RE: BJ's Restaurant
10000 COORS BYPASS BLVD NW

SUBJECT: Comments dated 7/24/2014
Permit # B14D004E

CS

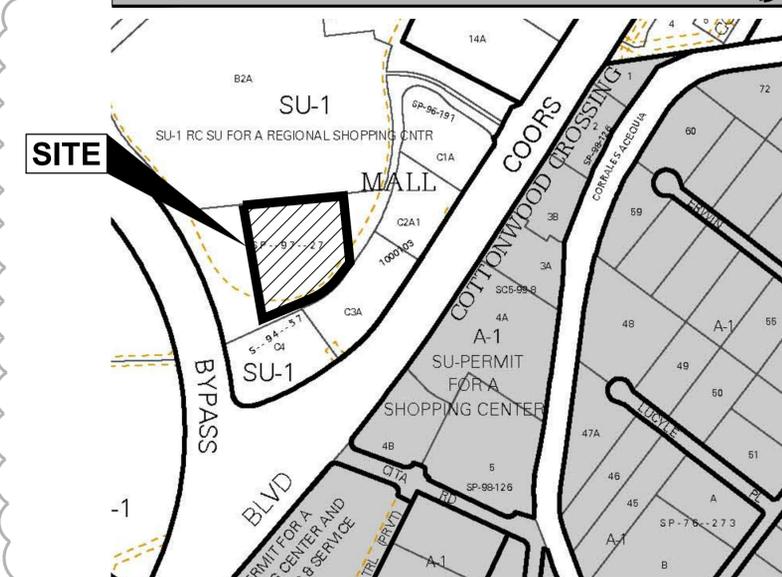
3. Provide assumptions and calculations for the storm pipe and valley gutter that show all are sized appropriately. The drainage assumptions should follow the 1992 Drainage Report for Cottonwood Mall by Bohannon-Huston, Inc. Include a valley gutter detail.

Response: Per conference call on 09/04/14 with Curtis, we are providing a project description on title sheet that would include

existing and proposed conditions. Please see Cover Sheet.

**C1** **SITE IMPROVEMENT PLAN**

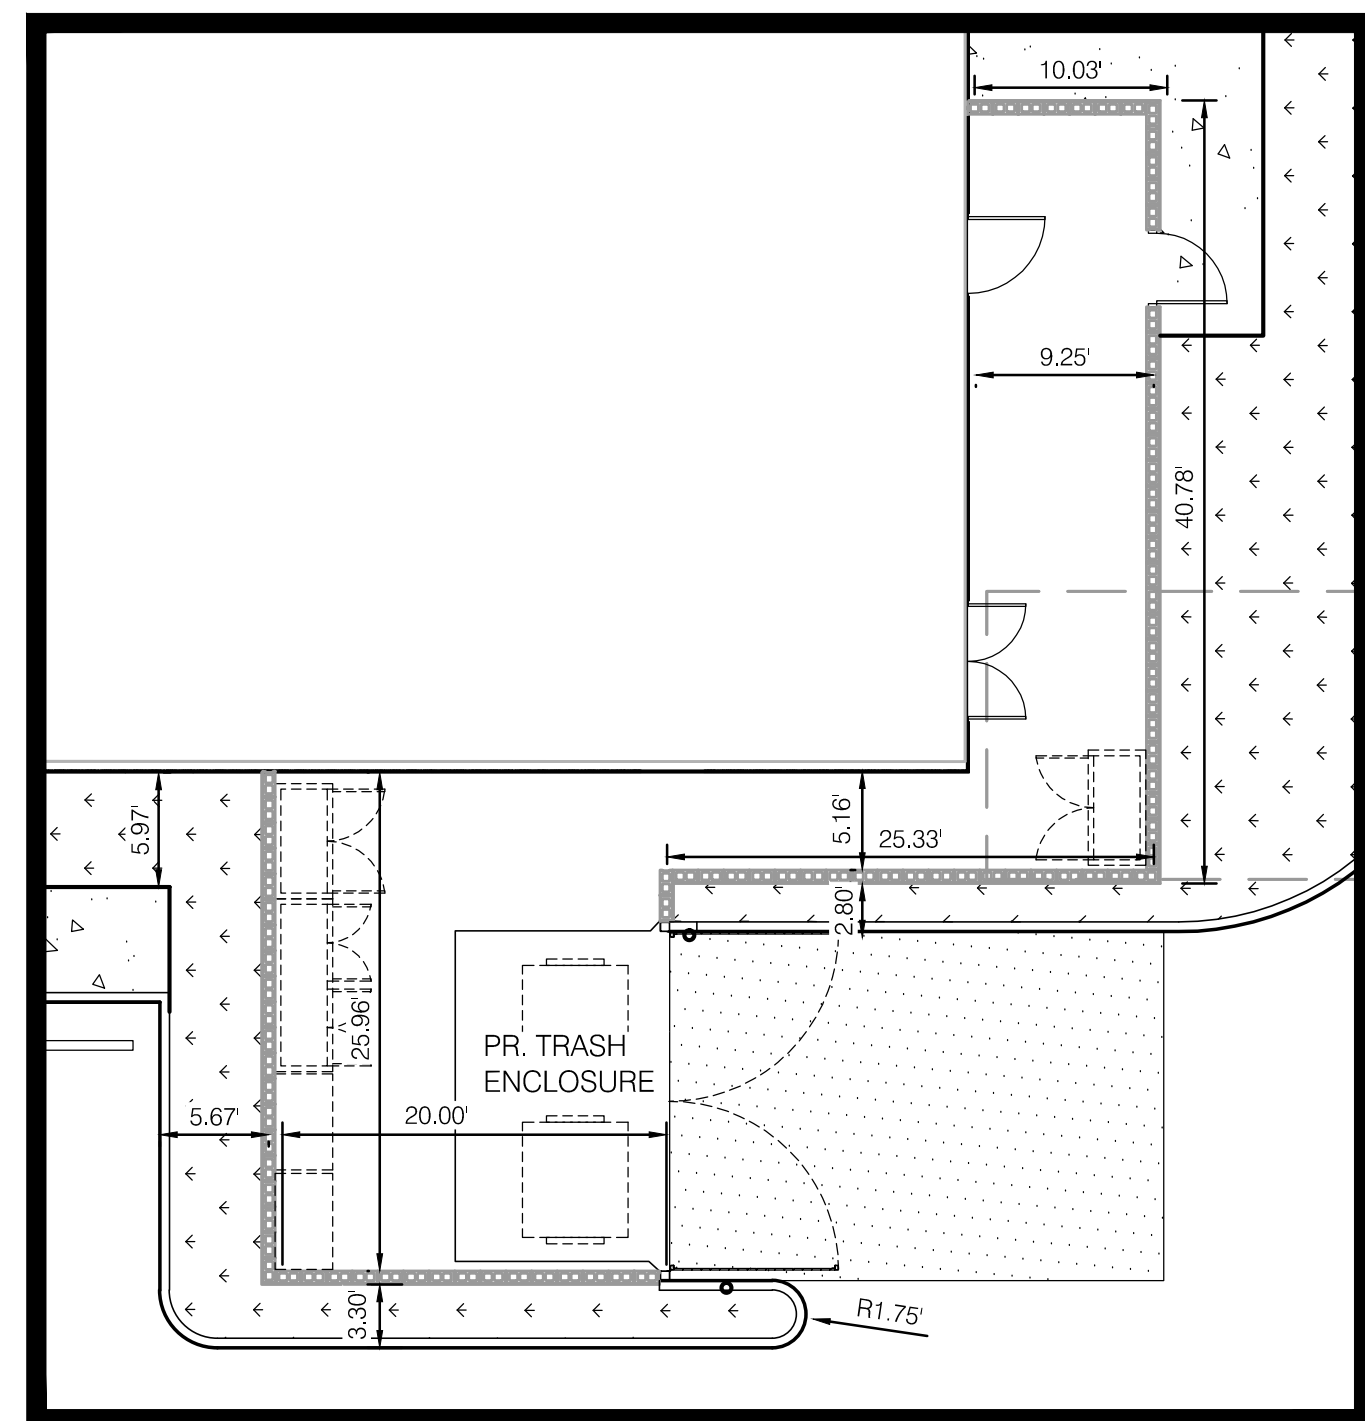
5. Include openings in all the islands for drainage to enter.

Response: After discussions with Mr. Curtis A Cherne, we concluded that we would provide curb openings as existing (grading) conditions would allow. We still were able to provide curb openings on many landscape islands. Please refer to sheet C1.

C2

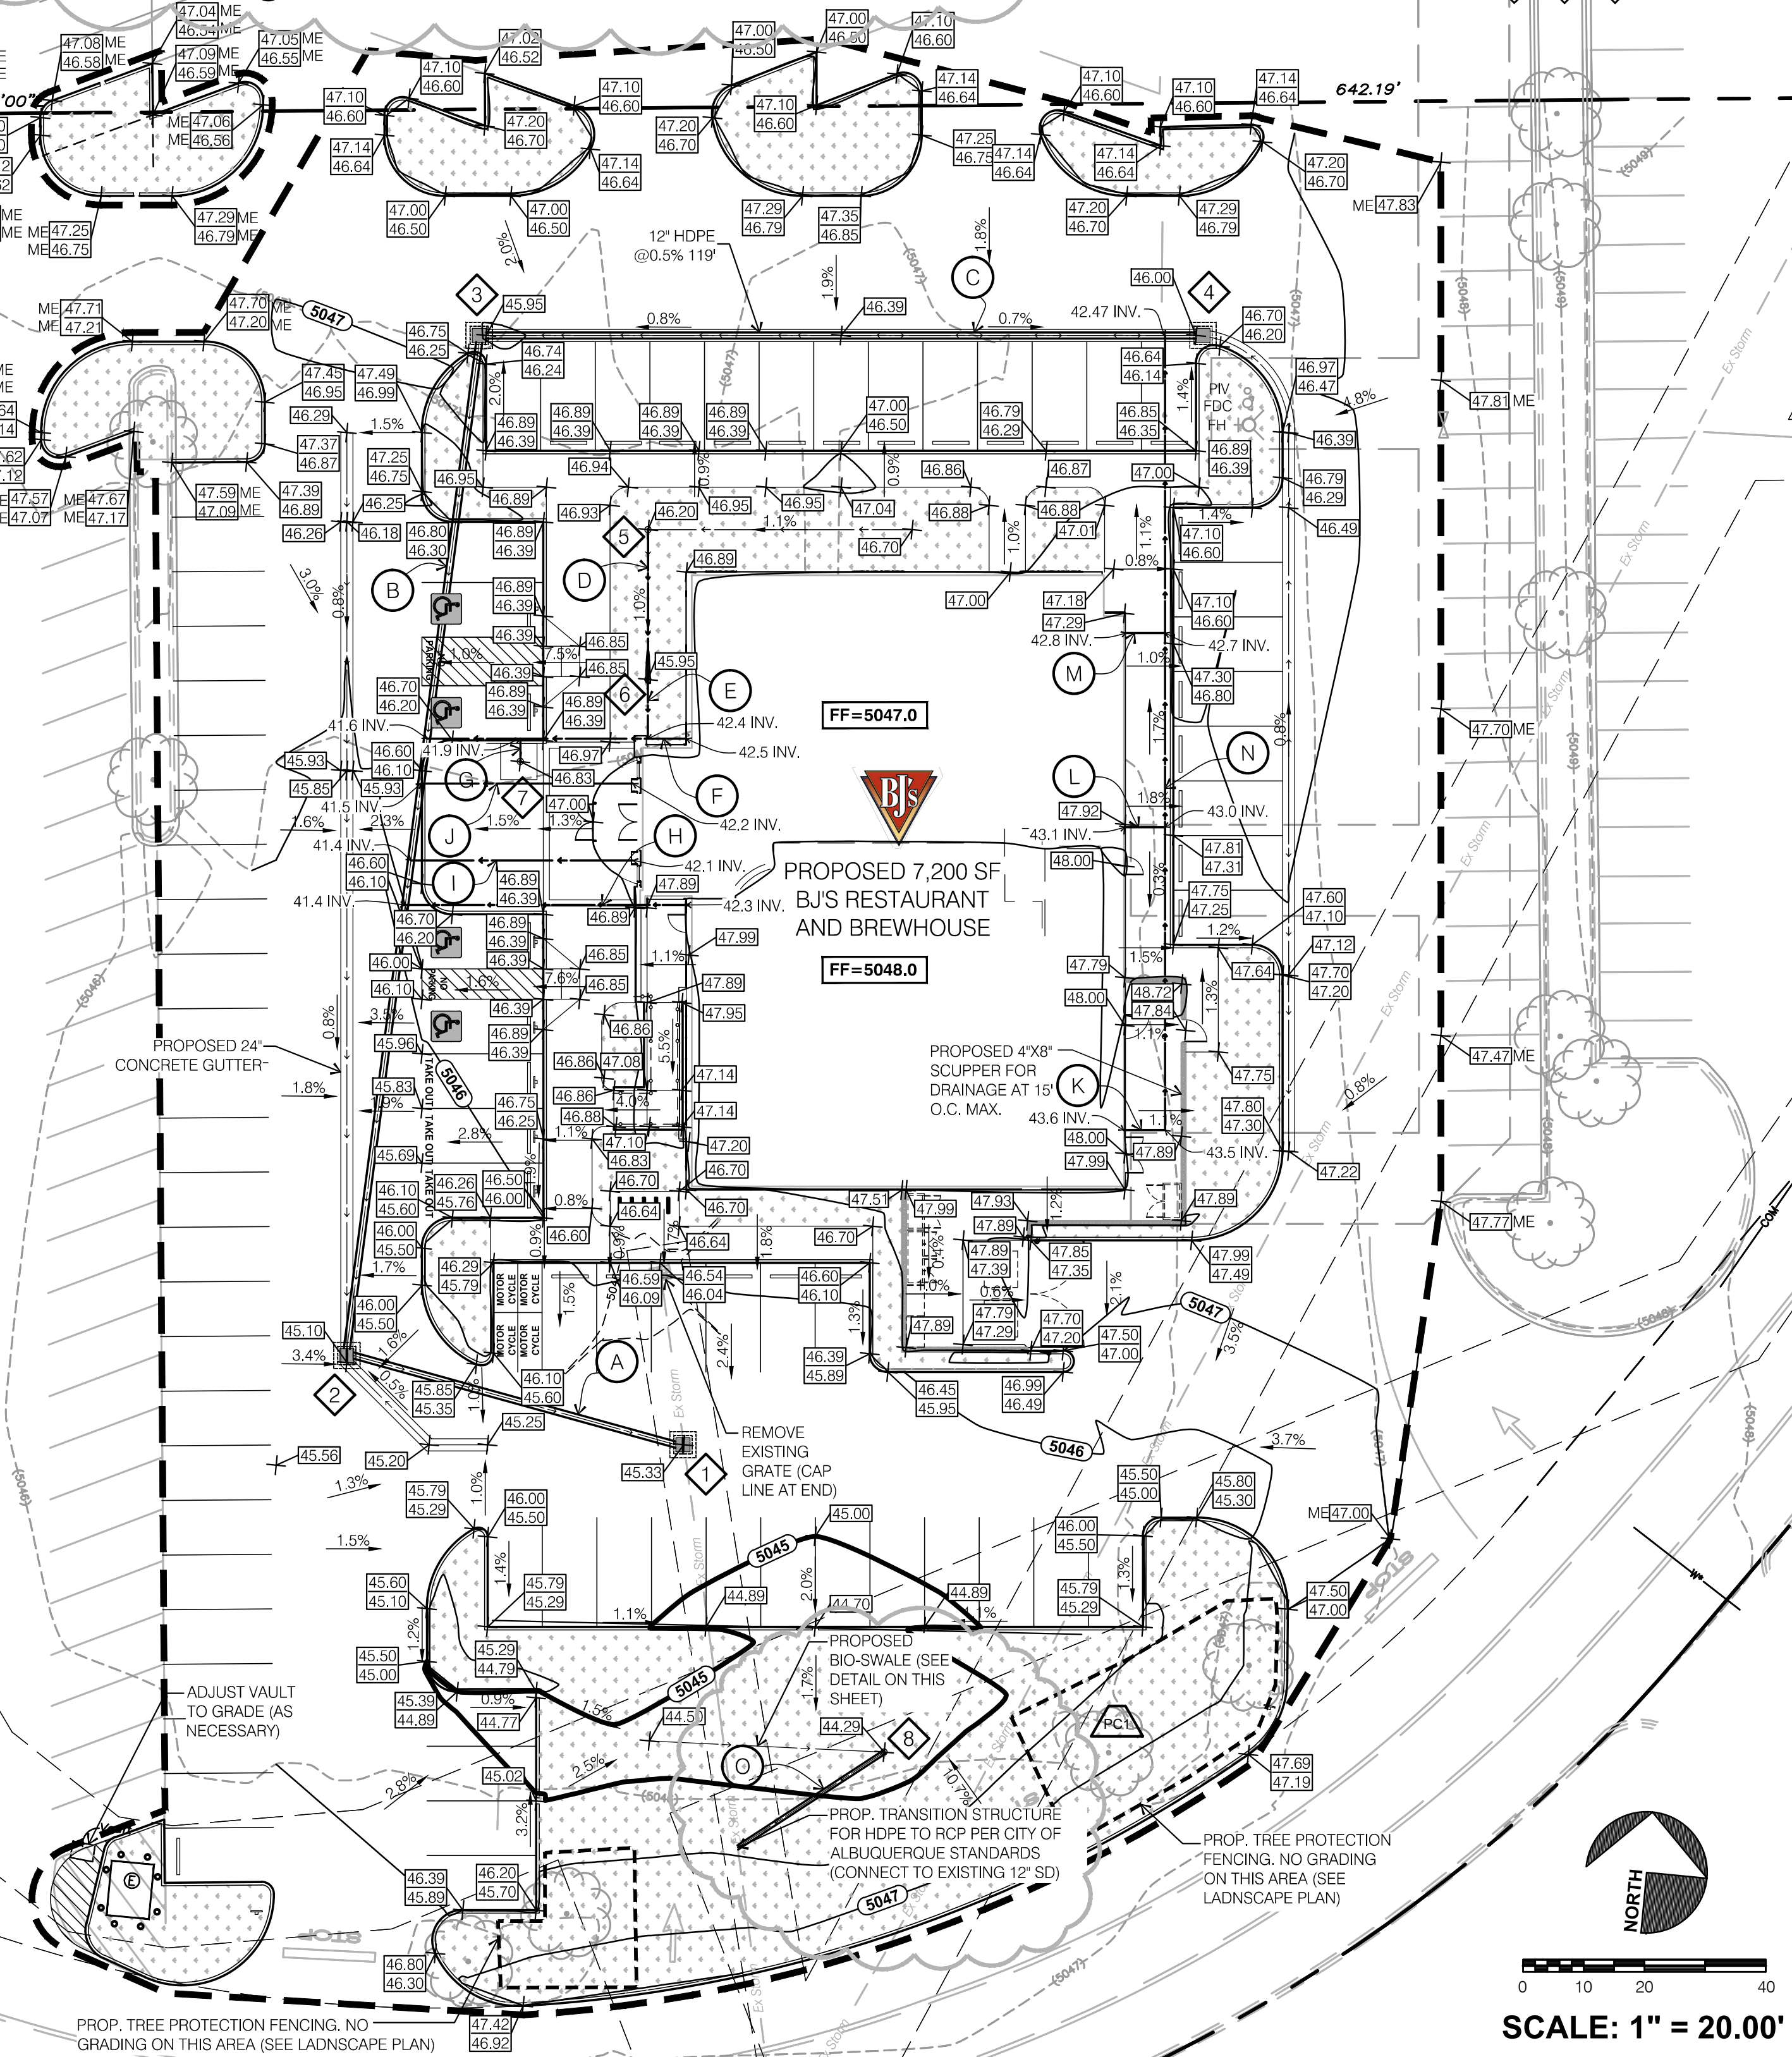
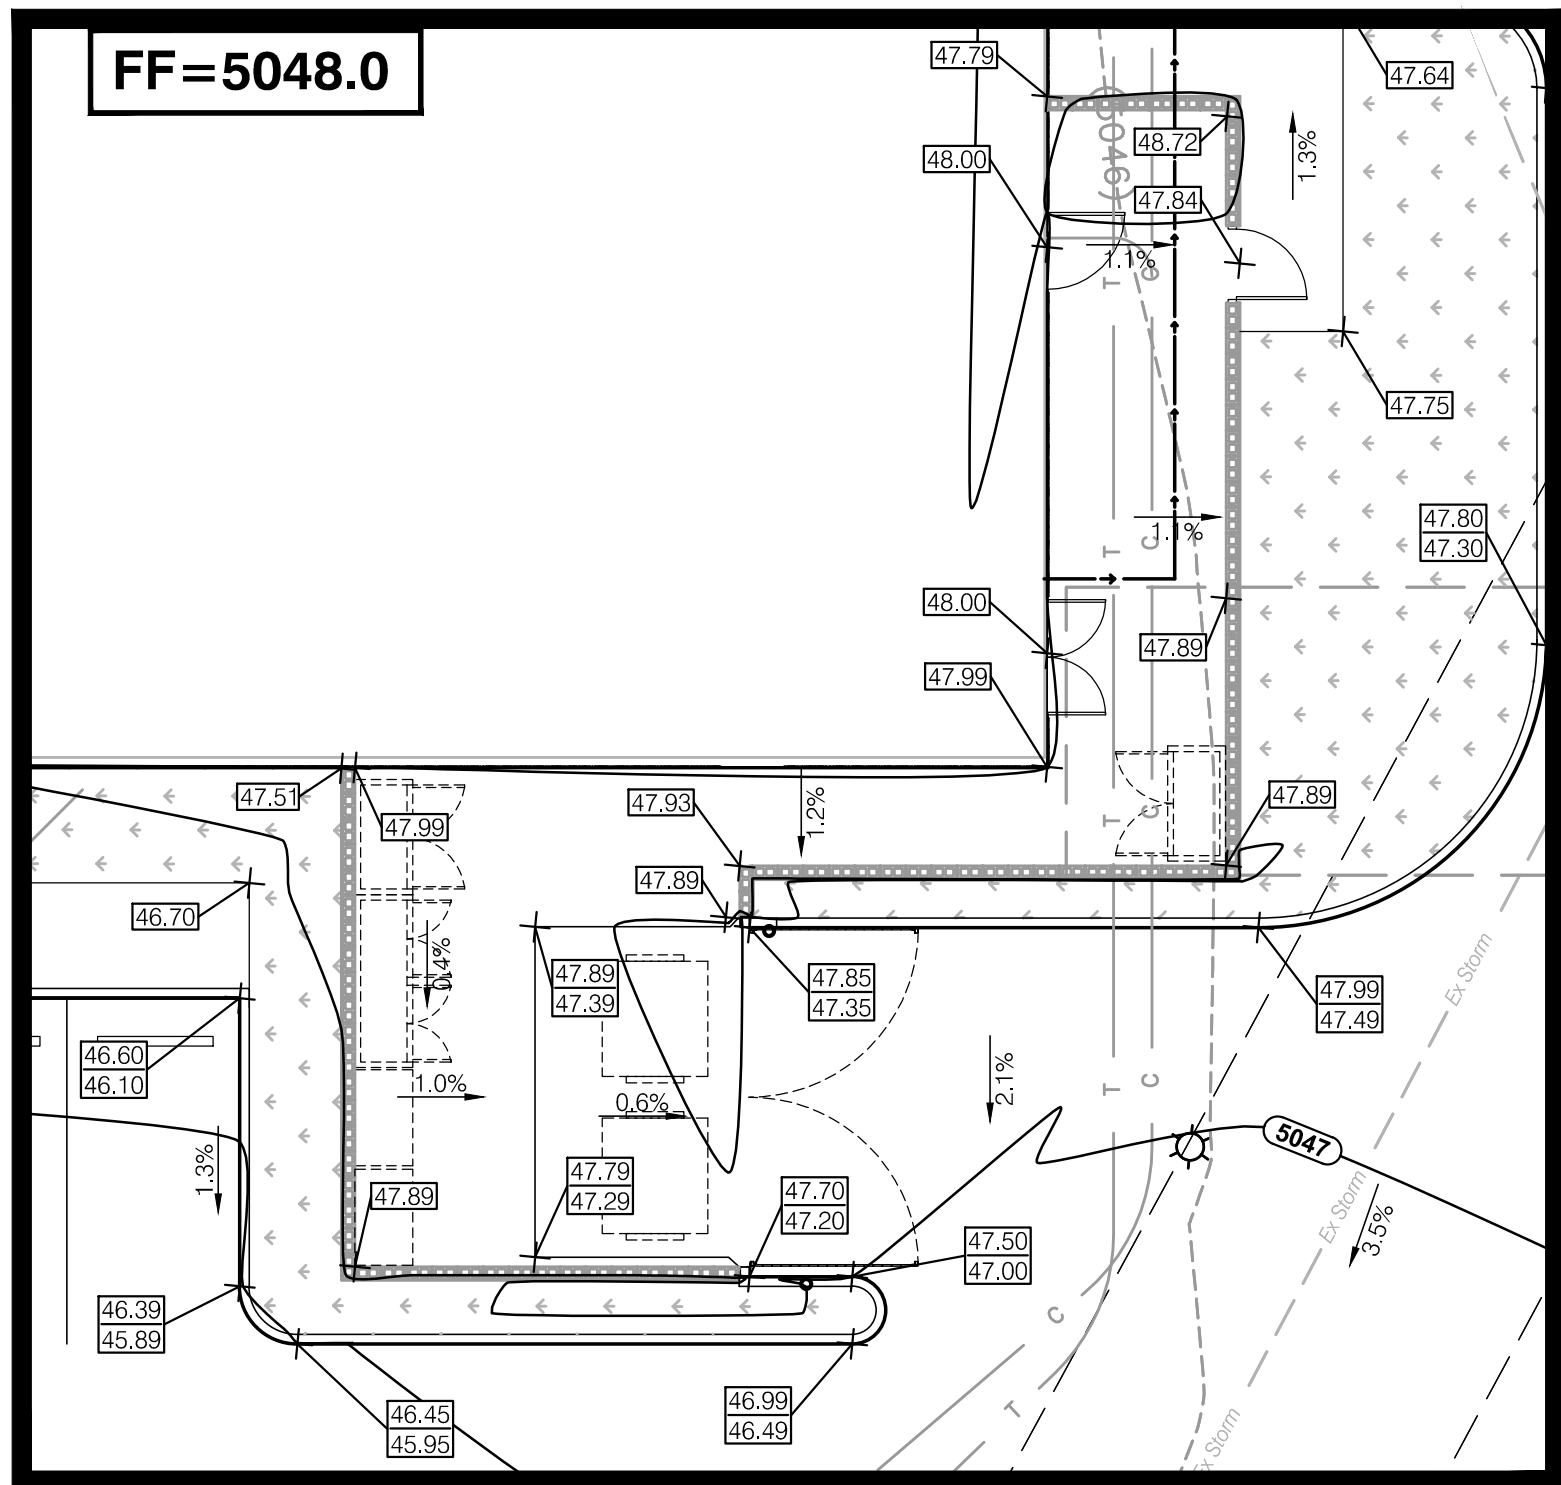
1. Schedule Note C states the storm pipe is 12 inch, but Schedule Note 4 calls out a 4 inch invert. Revise Note 4. Provide a call out for Schedule Note 8 and size of pipe. Call out a transition for connecting HDPE to concrete pipe.

Response: This has been updated per comment. Please see Sheet C2.

4. No bio-swale detail is provided as has been called out. Provide the detail.

Response: Detail added on sheet C2. Concrete gutter and Concrete Curb Cut-Off detail are included on sheet C6.
